# CITY OF ALBUQUERQUE

March 6, 2017

**RE:** Starbucks and T-Mobile  
Lot 3B and 4A Krania Subdivision  
Grading and Drainage Plan  
Engineer's Stamp Date 2-23-2017 (File: K09D031C)

ENGINEER'S SEAL  DAVID SOULE P.E. #14522	STARBUCKS/ T MOBILE GRADING AND DRAINAGE PLAN	DRAWN BY WCWJ DATE 2-24-17 21645-LAYOUT-12-05-16
	 Rio Grande Engineering 1806 CENTRAL AVENUE SUITE 201 ALBUQUERQUE, NM 87106 (505) 872-0999	SHEET # - JOB # 21645

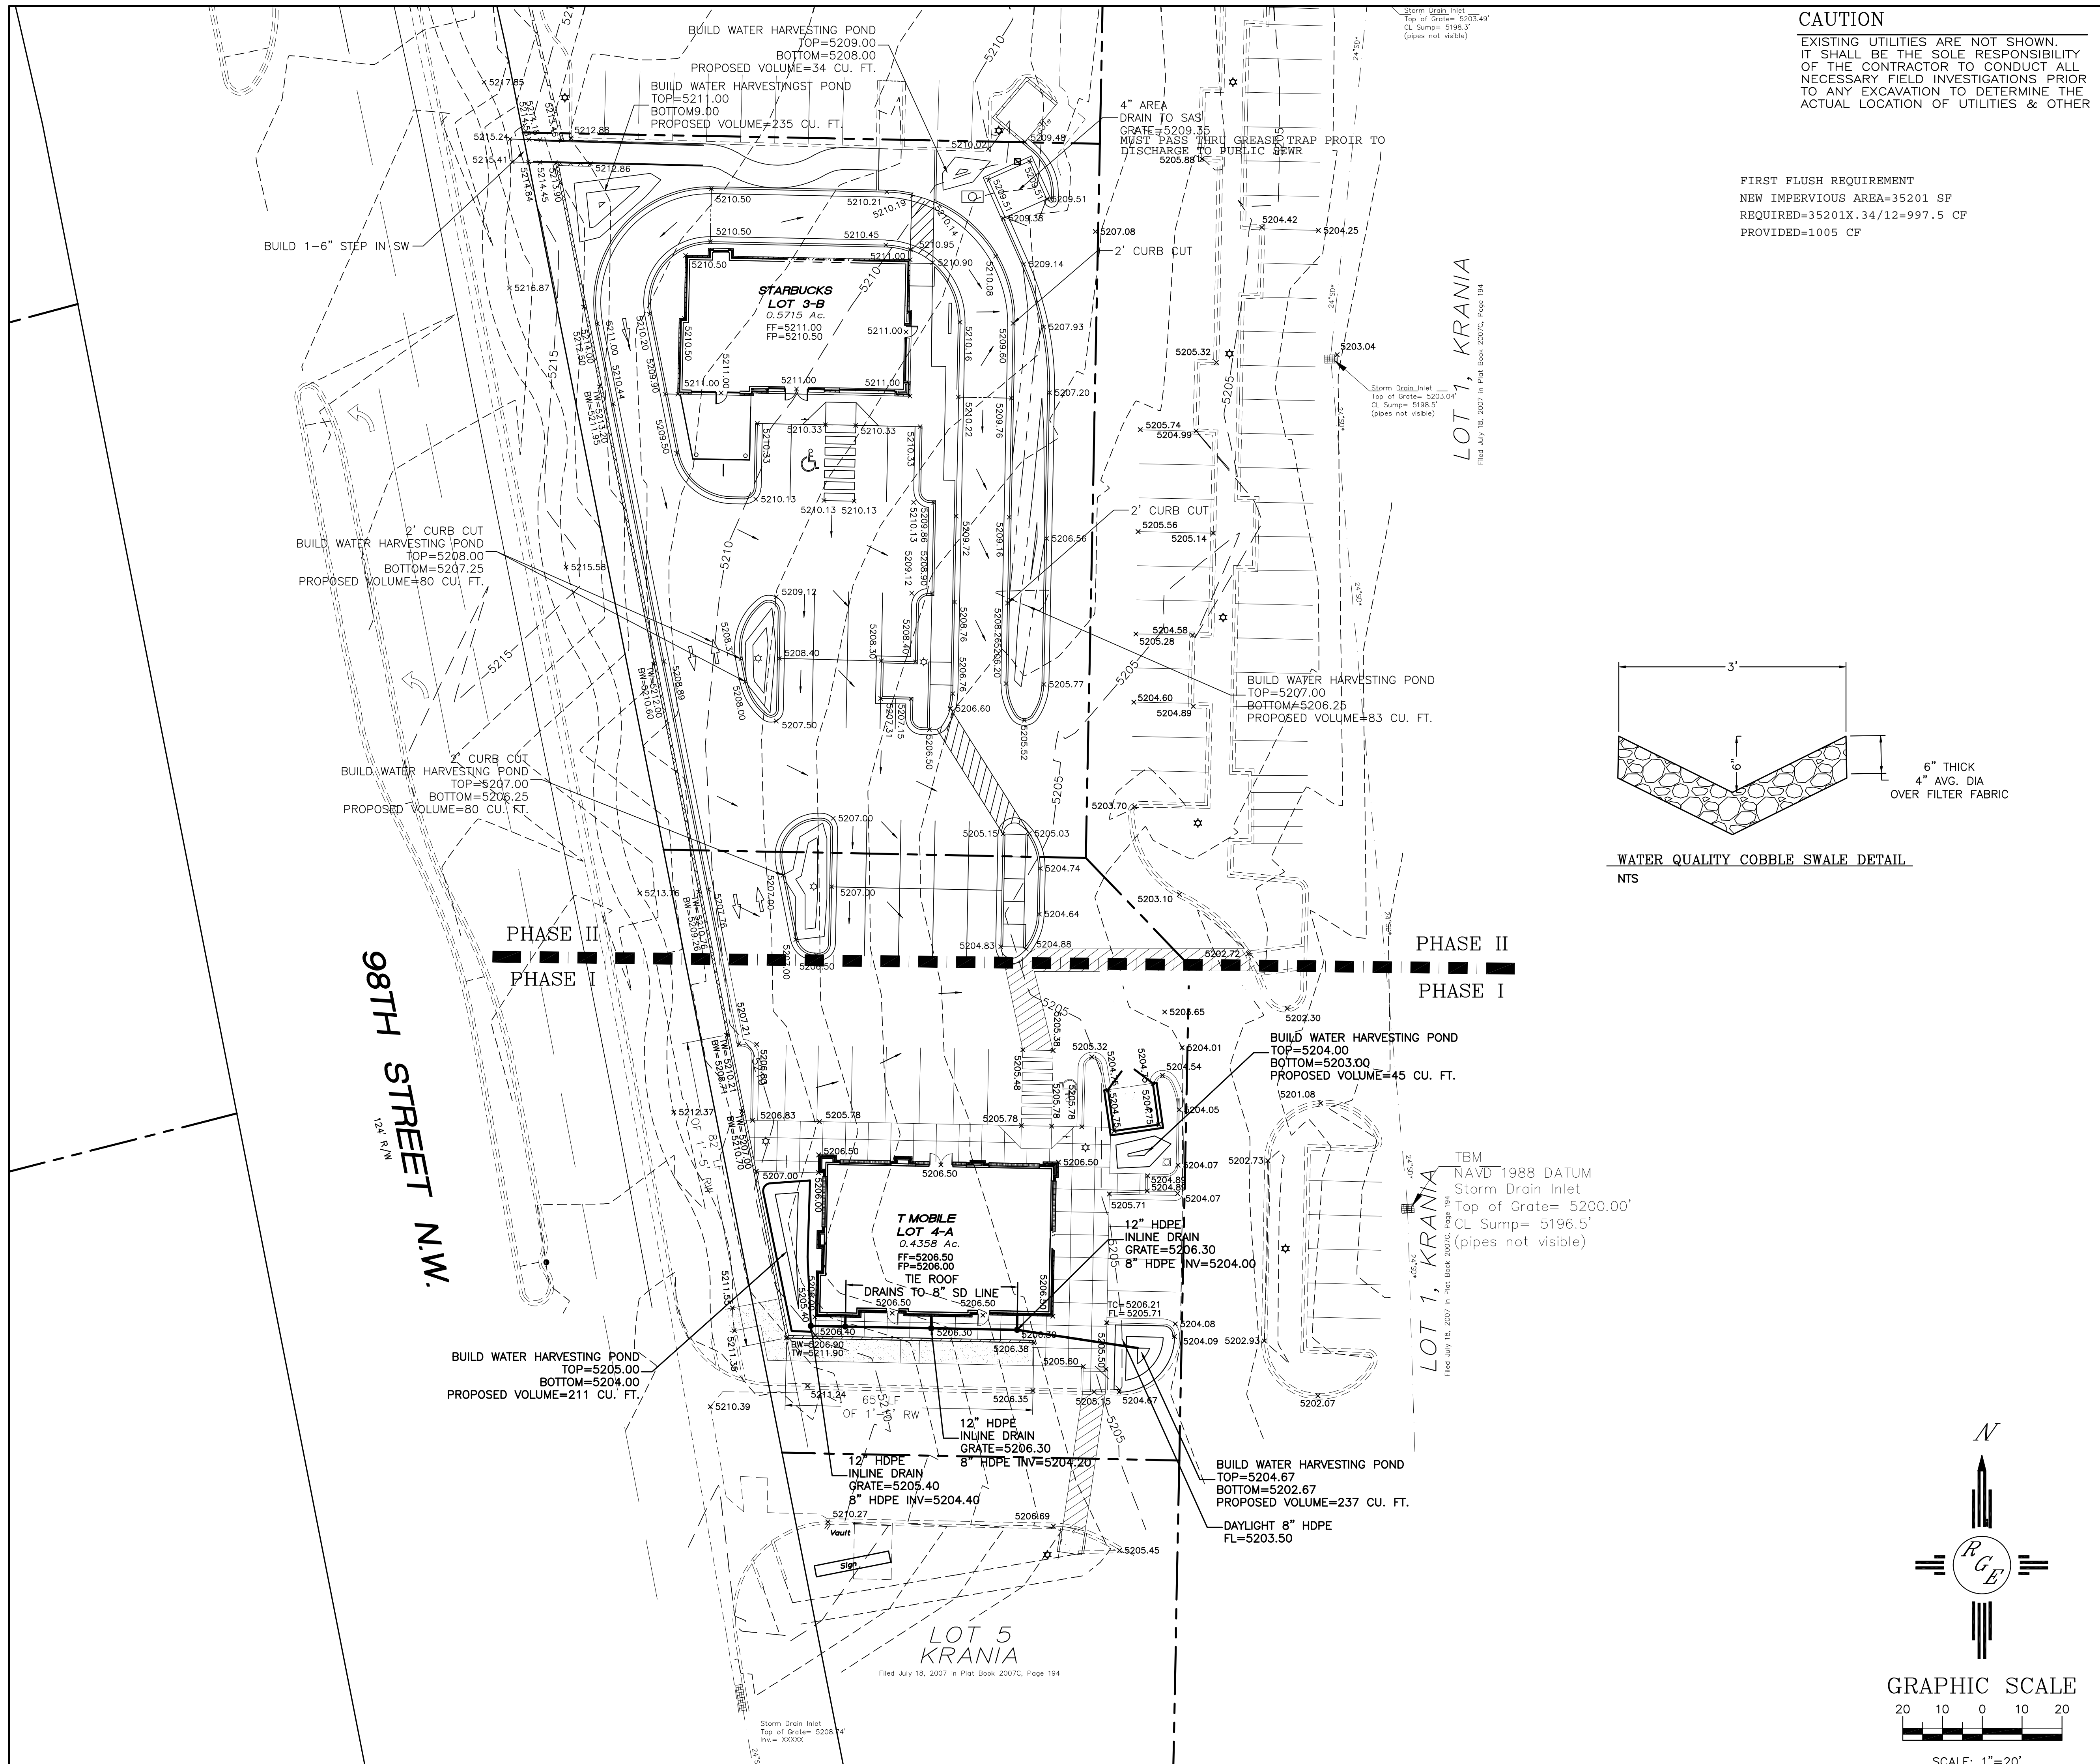
1. The drain must be extended to a grease trap and then to sanitary sewer system.
2. T-Mobile doesn't need area drain for trash enclosure.
3. Provide cross access and drainage easement. The survey provided doesn't provide the cross access of easement drainage.
4. Provide documentation allowing free discharge from this site.
